FG/170/18

I would like to oppose the conversion of the old Police Box in Ferring Street, into a property with no kitchen, garden or room for parking.

Proposed Site Layout

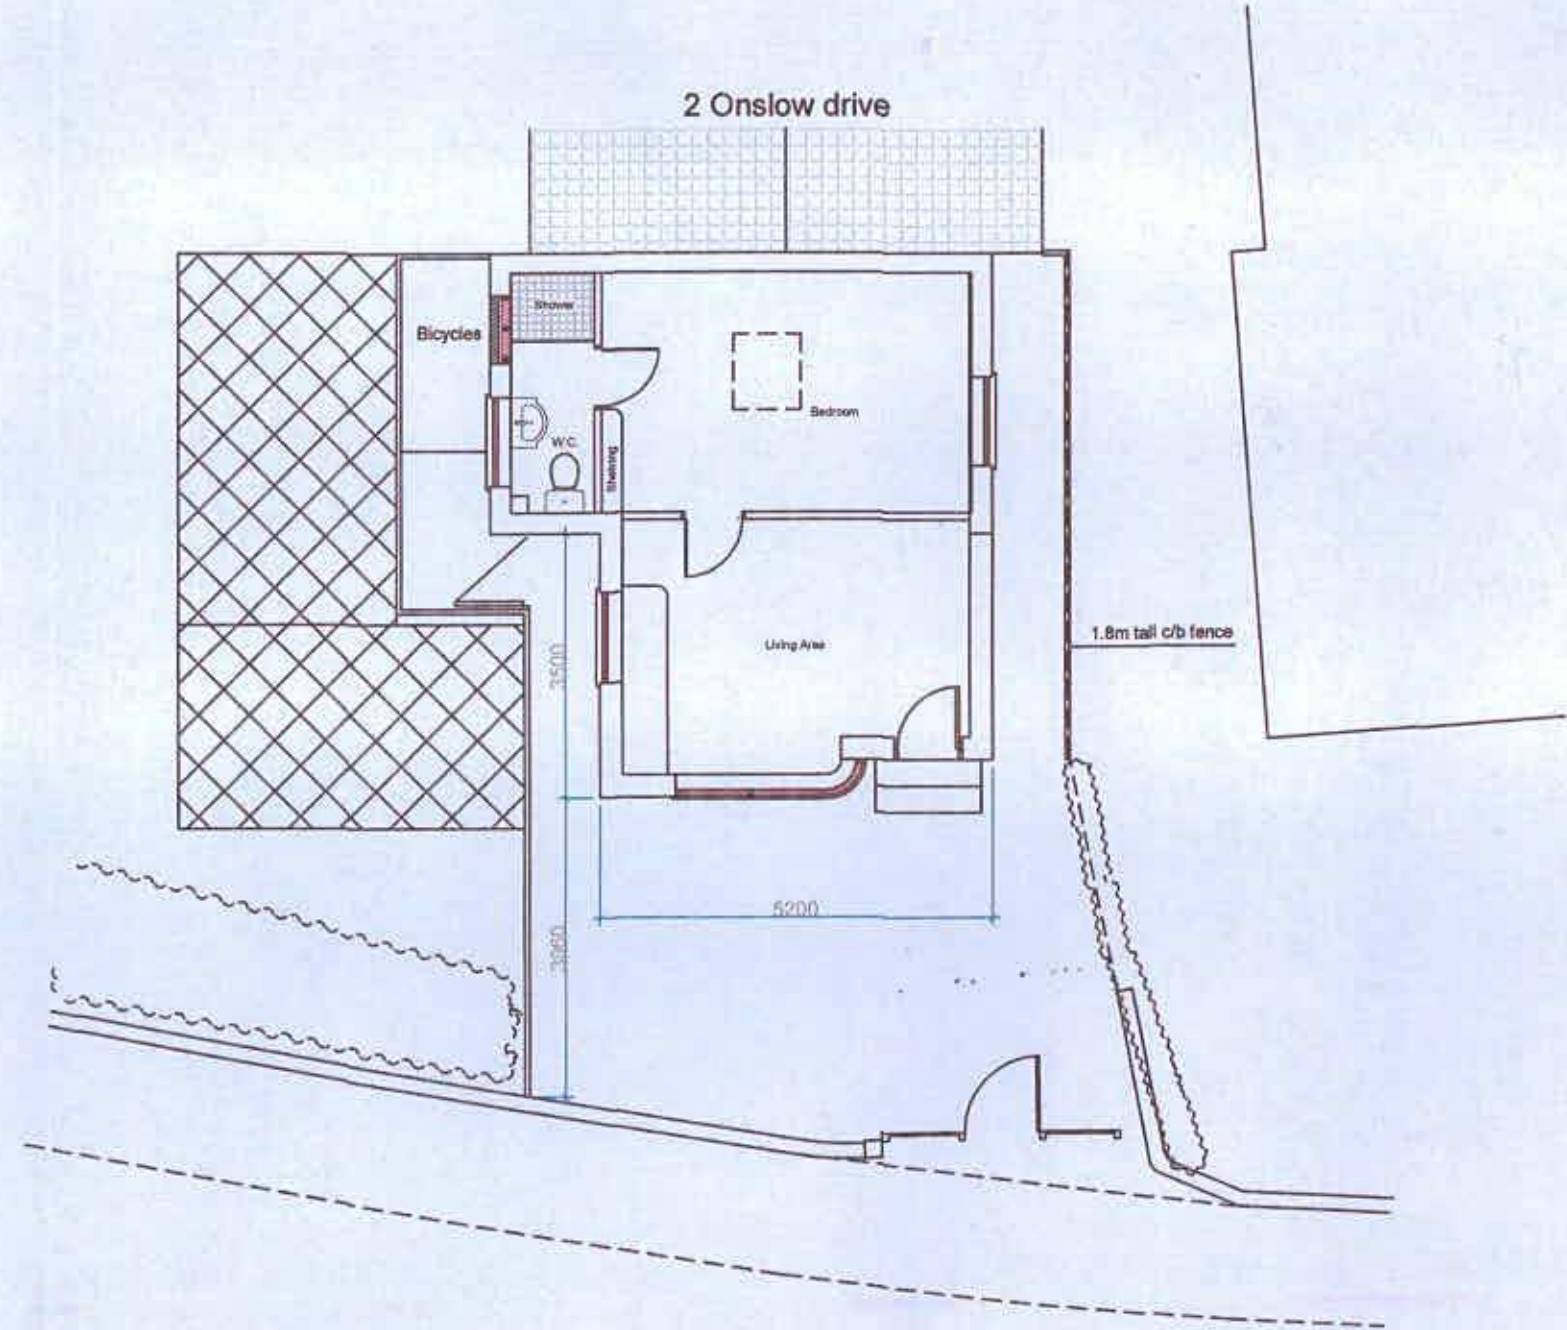
This is totally impractical and out of keeping in this area, in a very small plot.

Proposed Floor Plan

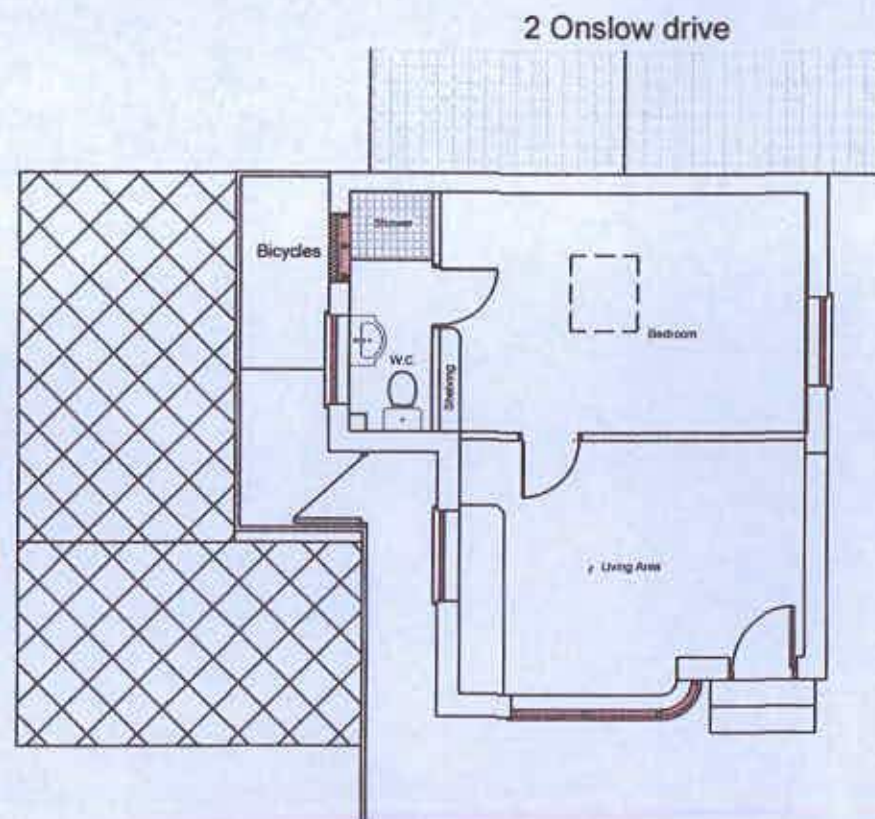
Where are the new owners going to eat? in the lake - areas opposite I suppose!
